KITTITAS COUNTY
DEPARTMENT OF PUBLIC WORKS

MEMORANDUM

TO: Mary Rill, Staff Planner, Community Development Services
FROM: Randy Carbarry, Planner II *RC*
DATE: April 9, 2007
SUBJECT: Trent Short Plat

TRENT SHORT PLAT - NO. SP-07-26
 LOCATED IN SECTION 9, T-21 NORTH, R-14 EAST, W.M.
 KITTITAS COUNTY, WASHINGTON

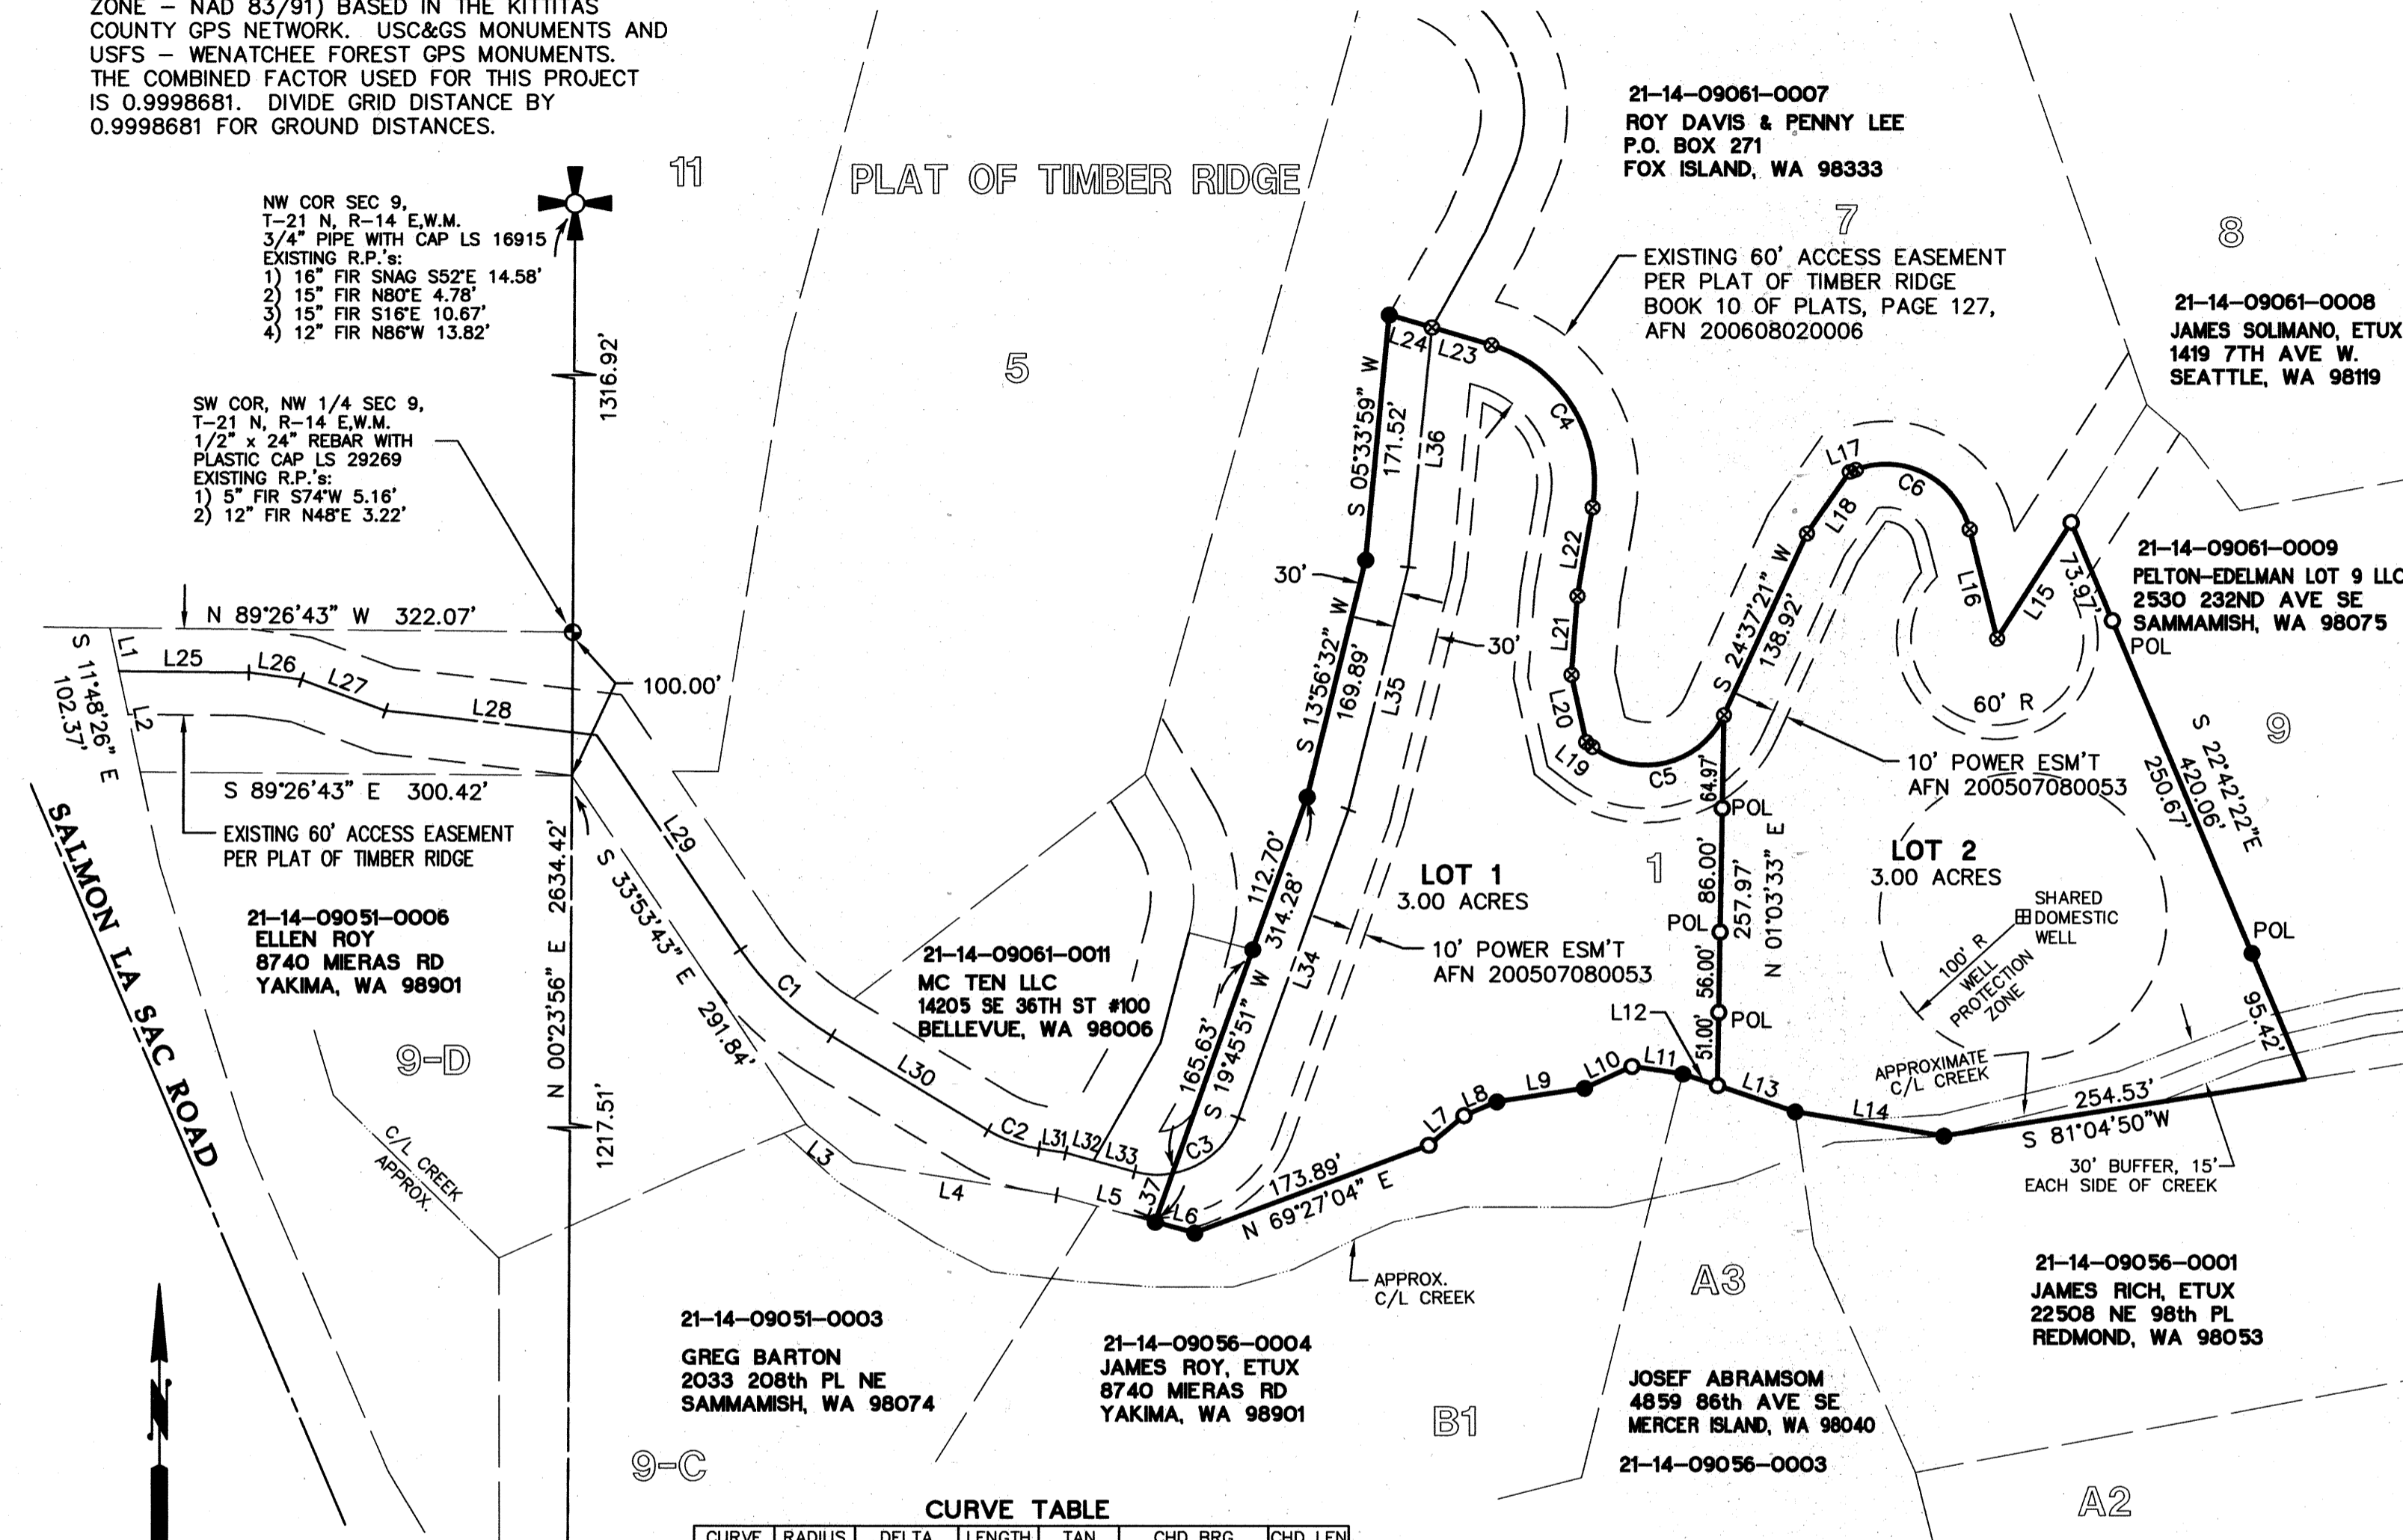
1. Gated Entrance: It appears that the access to this development has entrance and exit security gates that are currently under construction which are each only 12' wide. The International Fire Code requires a minimum unobstructed width of 20', unless otherwise approved by the Fire Code Official. The applicant shall provide documentation of approval from the Kittitas County Fire Code Official for these gates prior to final plat approval.

JOVANOVIH SHORT PLAT - NO. SP--
 LOCATED IN SECTION 9, T-21 NORTH, R-14 EAST, W.M.
 KITITAS COUNTY, WASHINGTON

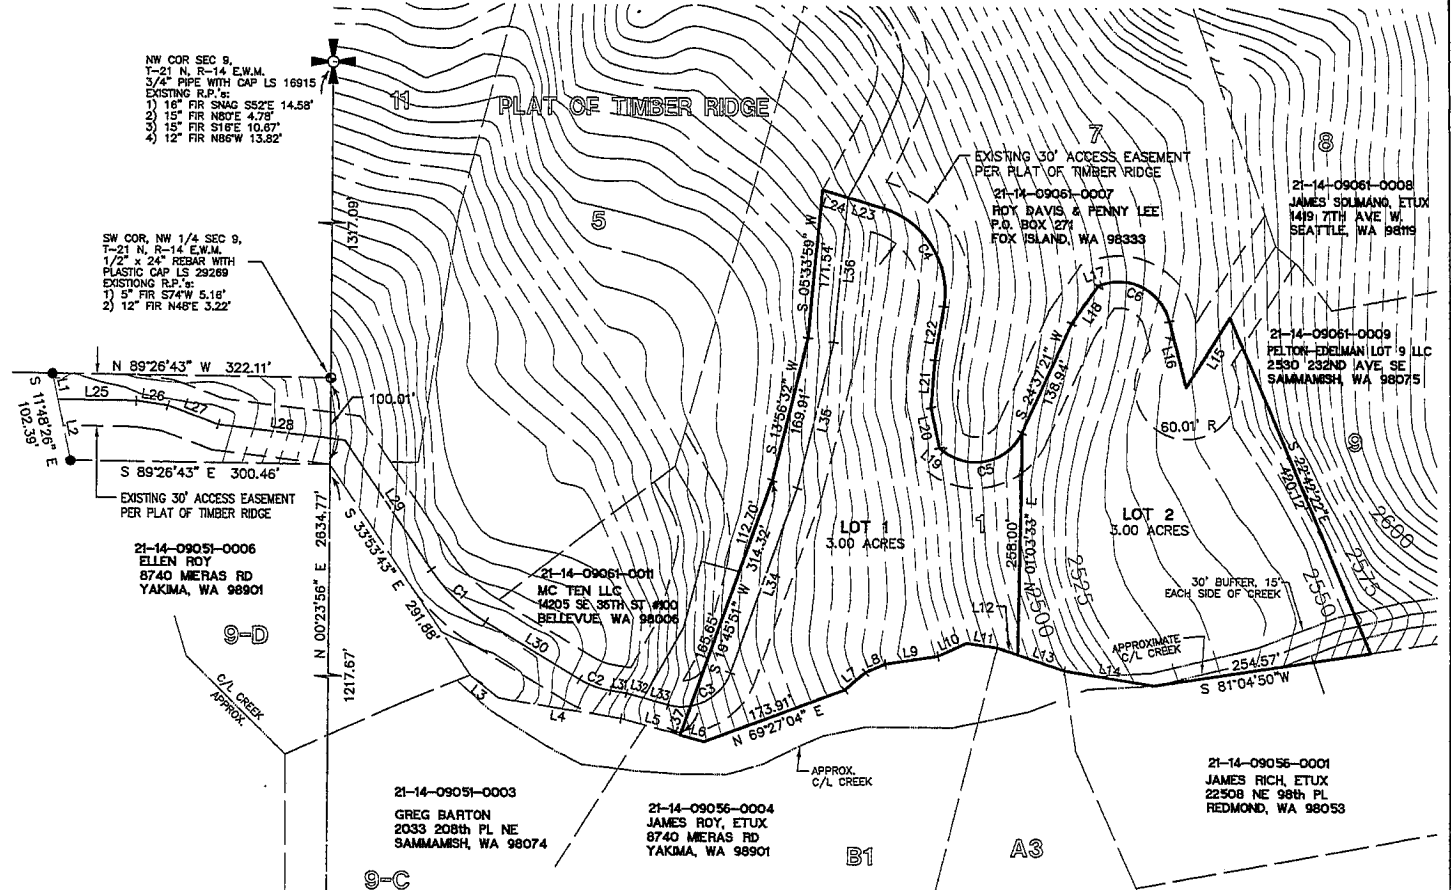
2. Access Easement: The "Existing 30' Access Easement per Plat of Timber Ridge" appears to be a 60' easement. The final plat shall accurately depict this easement and the Auditor's Recording Number (AFN) shall be shown on the face of the Plat.
